**From:** Jeff Tarling  
**To:** Jean Fraser  
**Date:** 11/10/2014 4:24 PM  
**Subject:** Re: Final Landscape Plan 2282 Congress Fwd: Need sign off please: FW: City's Technical Std re Landscape

Call me to discuss adding a note to the C 5.0 Landscape Plan pointing to the MTA land area between the pylon sign and the entrance that reads:

SHEET TITLE
LANDSCAPE PLAN

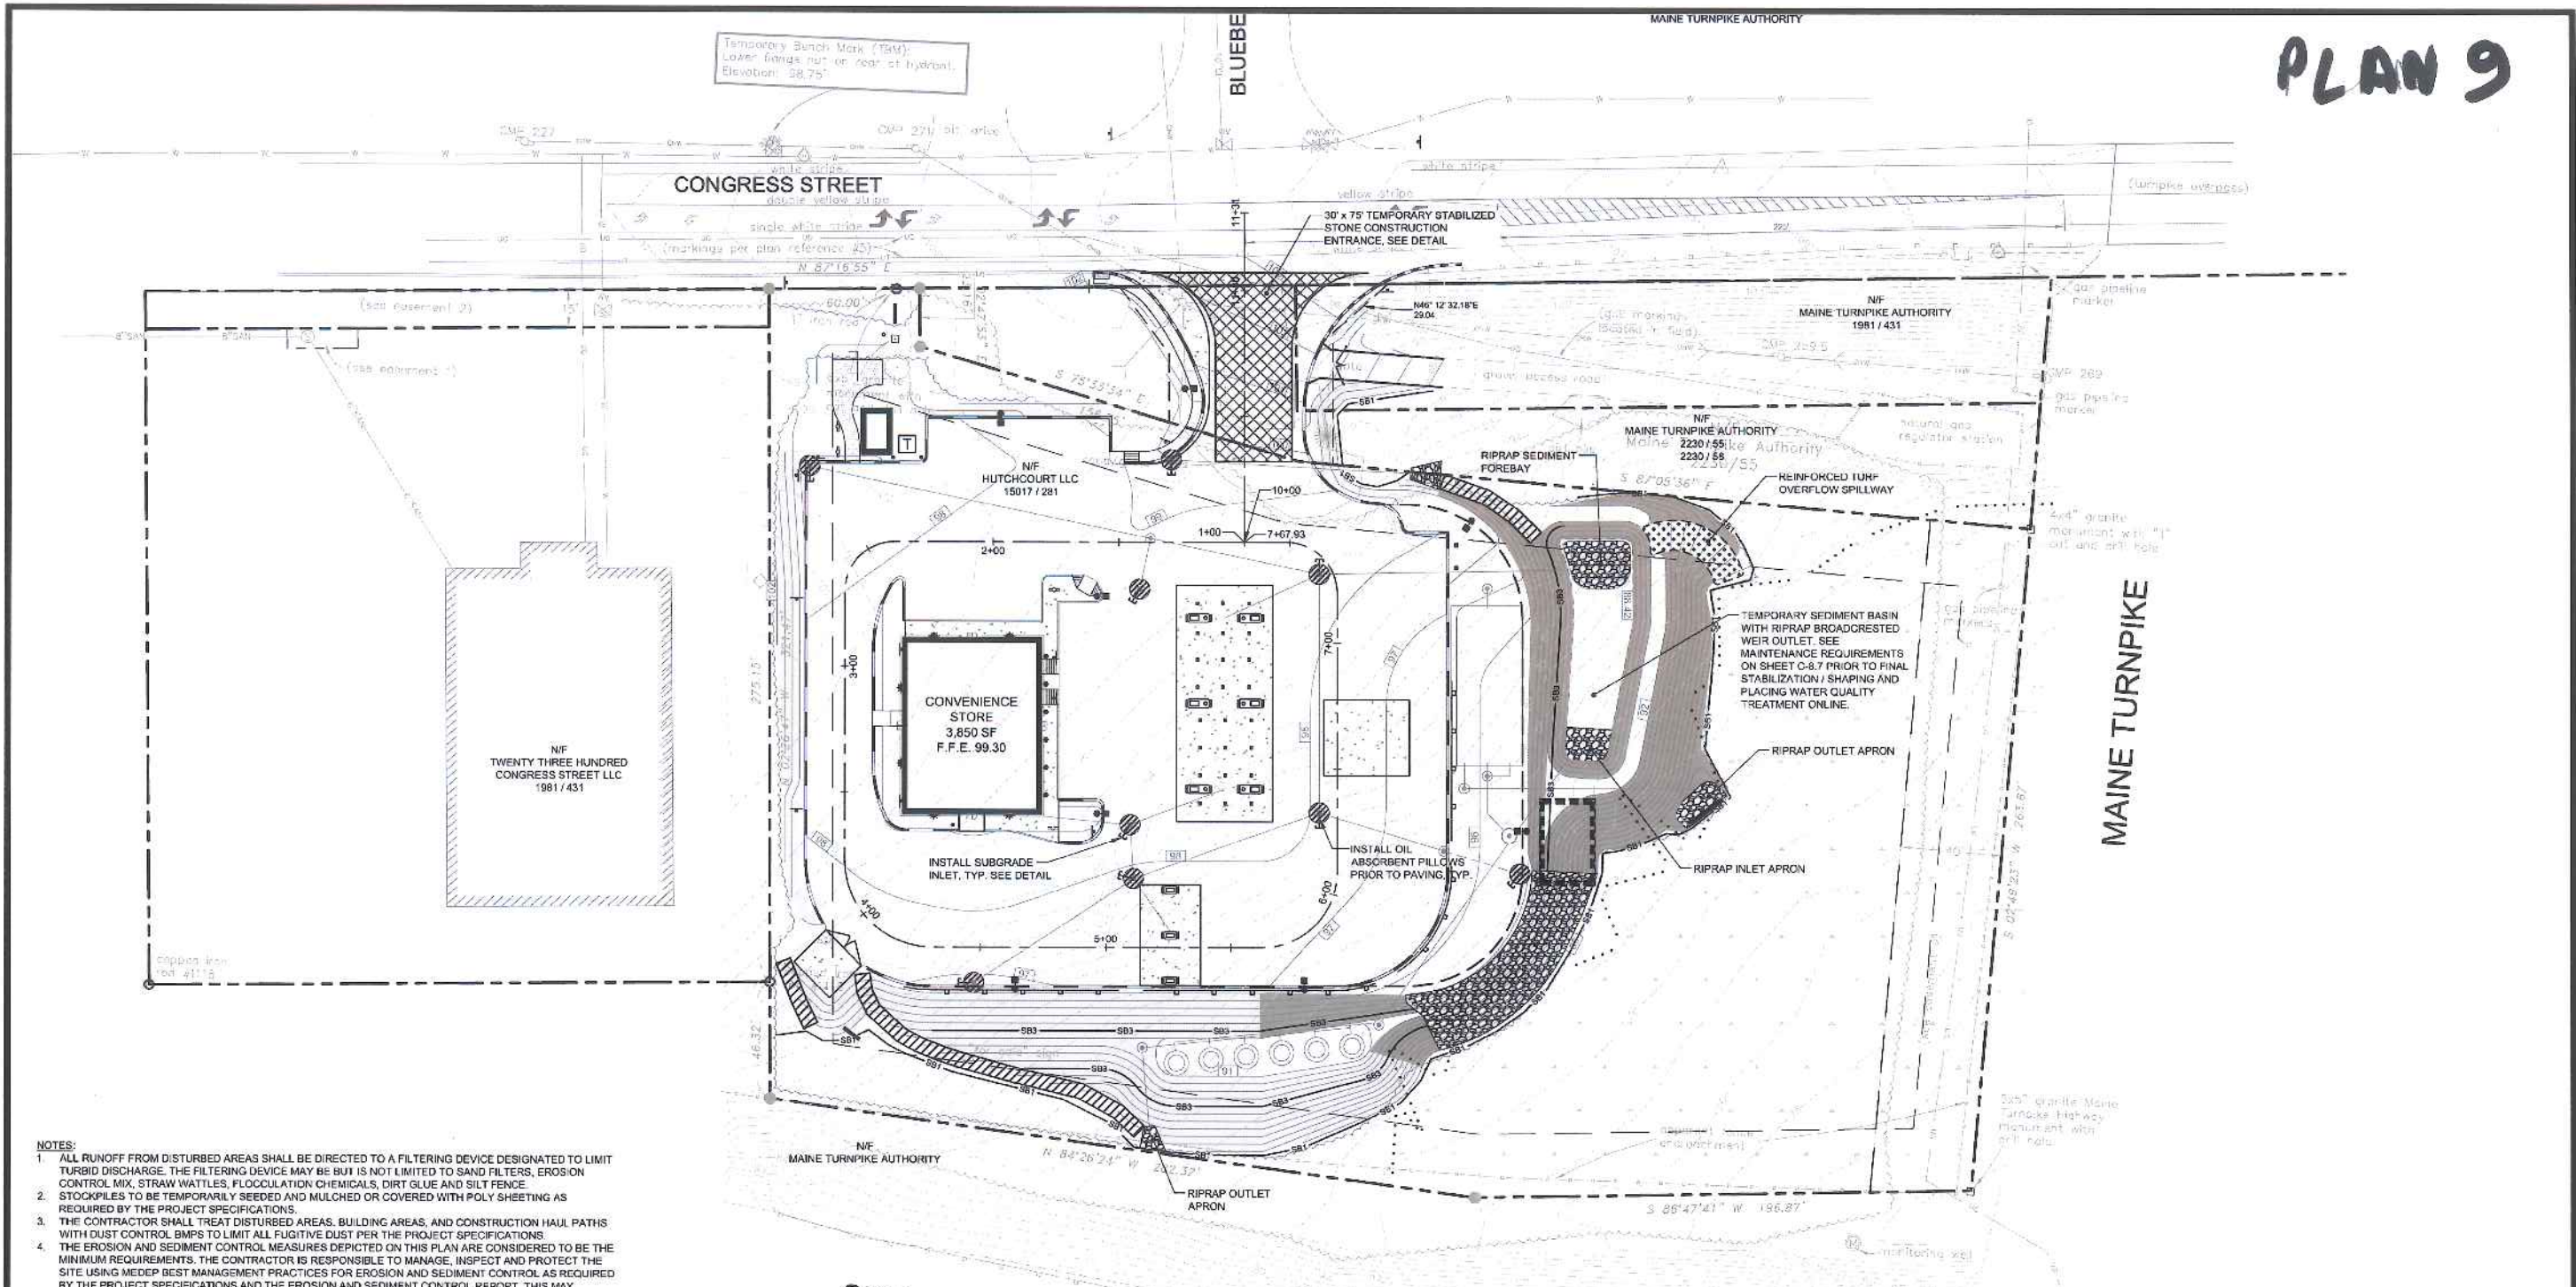
The situation has come about because the applicant had to move the access to the site over to be opposite Blueberry and this has entailed a very costly easement from MTA for the access drive over MTA land. The area where they would have preferred to have the access is now to have some tree preservation (ie where they own along Congress). MTA would not give them an larger easement (or would do so only with a very big price tag over and above an a large price tag for the drive access) but there is an informal agreement that the applicant can "improve" the area.

They have changed the pin oak to the swamp white oak that you recommended; they have also clarified re treesaves in the southern part of the site in addition to more and relocated trees around the basin.

I have indicated that a note on the plan would suffice regarding the area that you highlighted in your e-mail (given the land ownership) - as they have addressed all of your comments from the previous review and the current review. So there is a new note.....

*Subject to MTA's approval, improve the landscaping in this area. The improvements shall be in accordance with Section 4.7 Plant Selection of the City of Portland Technical Manual Section 7 Landscaping and Landscape Preservation.*
